NAME: \LAND PROJECTS\20180324-GLENEAGLE FIL 2\DWG\ROADWAY\03524-RDWAY-FIL2.DWG  
 PLOT DATE: December 4, 2018 6:43 AM BY: MIKE

VR-18-018

GLENEAGLE SUBDIVISION, FIL #2

STONE EAGLE PL PLAN AND PROFILE

MODIFIED TYPE 13 INLET
NOT TO SCALE

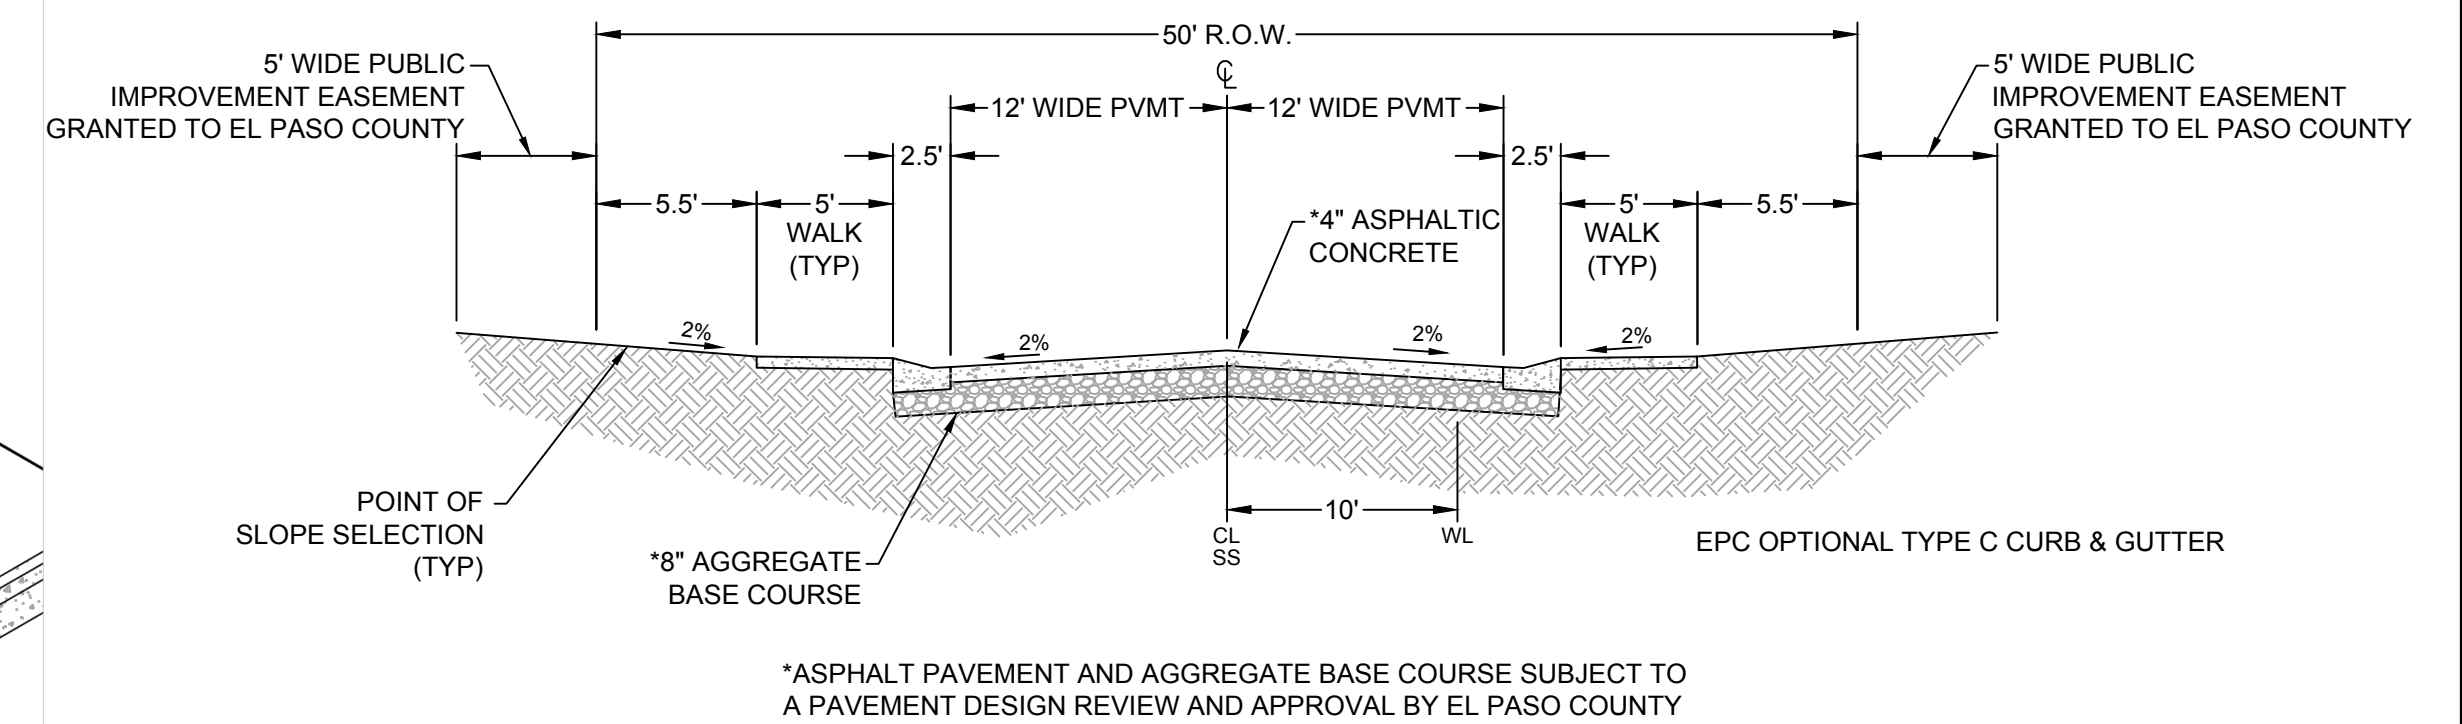
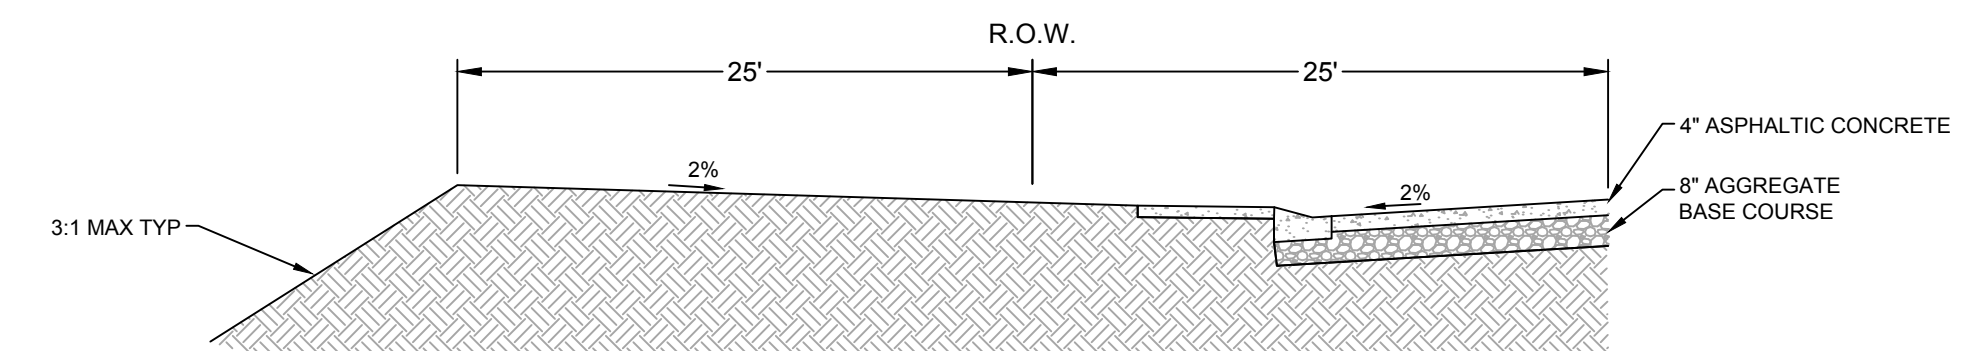
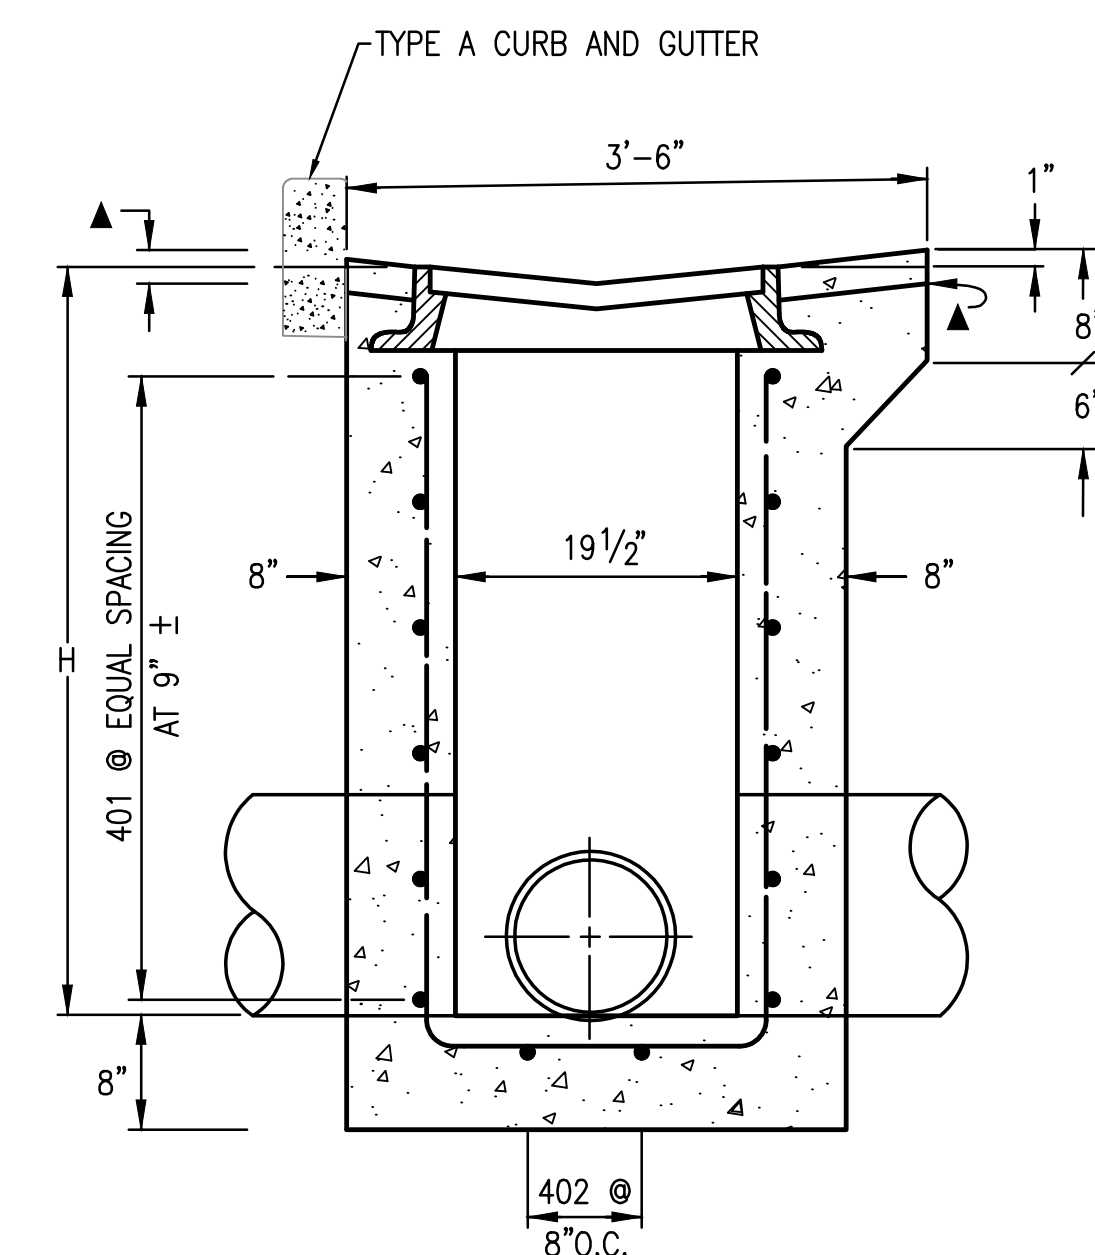
Call out: Asphalt pavement and aggregate base course subject to a pavement design review and approval by El Paso County.

Revise to curb inlets.
